Re: Liddell Coal Operations Modification 5

Liddell Coal Operations Modification 5

COUNCIL SUBMISSION

APPENDIX 3:  
CONCEPTUAL FINAL LANDFORM DESIGN

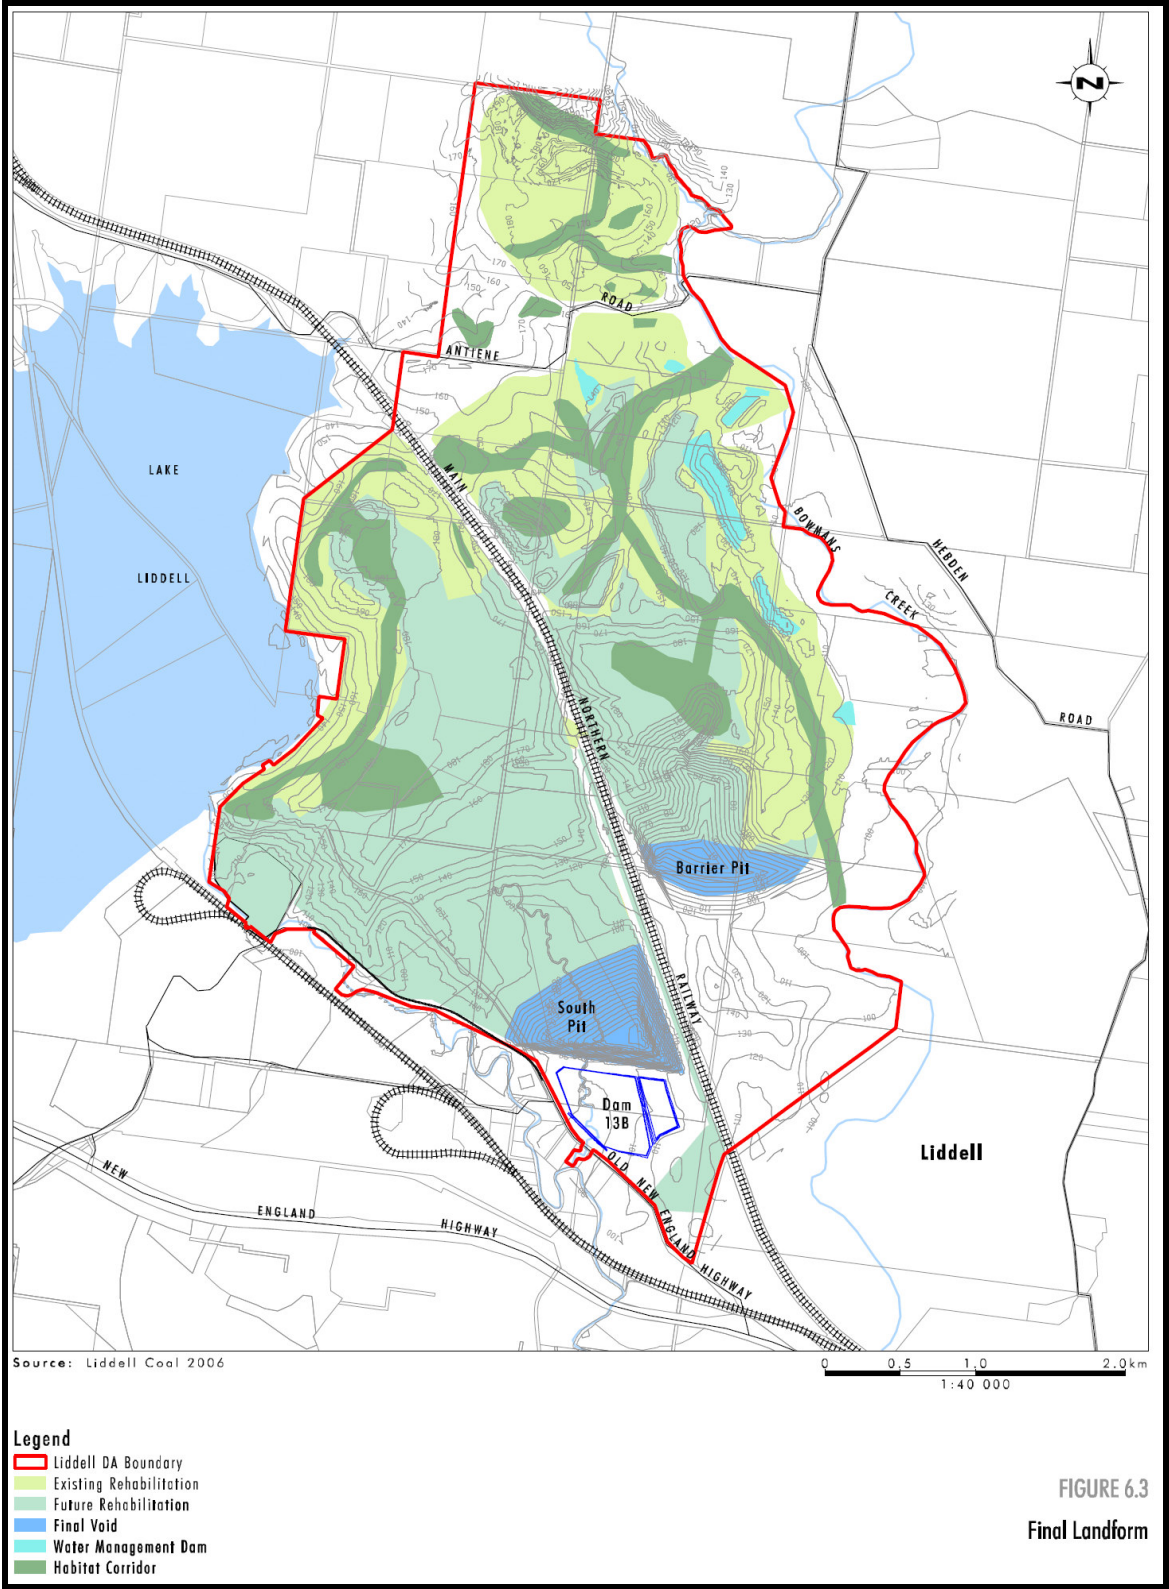
16. The Project includes a conceptual final landform that includes expansive planar slopes and a distinct lack of micro relief and natural appearance. This is particularly evident from Lake Liddell and the Main North rail corridor, which carries passenger

rail services. The landscape plan falls well short of best practice being deployed at neighbouring mines.

19. The proposal on public exhibition is silent on the alleviation of the visual impact of the final landform from prominent vantage points. Council has a long held policy that rehabilitated landforms should look natural.

21. The final landform includes two voids in which no effort has been made to create a more natural looking void landscape.
22. These voids appear to be greater in size than previously approved. Council's policy is to seek reduction in mining void size or removal altogether is not practical use can be found.

23. The final landform includes a final landform void. No effort has been made to create a more natural looking void landscape. The Conceptual final landform appears as if there is no doubt that further mining approvals would be sought and granted.

25. Council requests that in addition to the indicative detailed cross sections of the proposed void, indication of the depth of contained water, grade of all slopes approaching water body, catchment area, vegetation within the catchment area, areas of exclusion of stock, vehicles and pedestrians should also be provided.
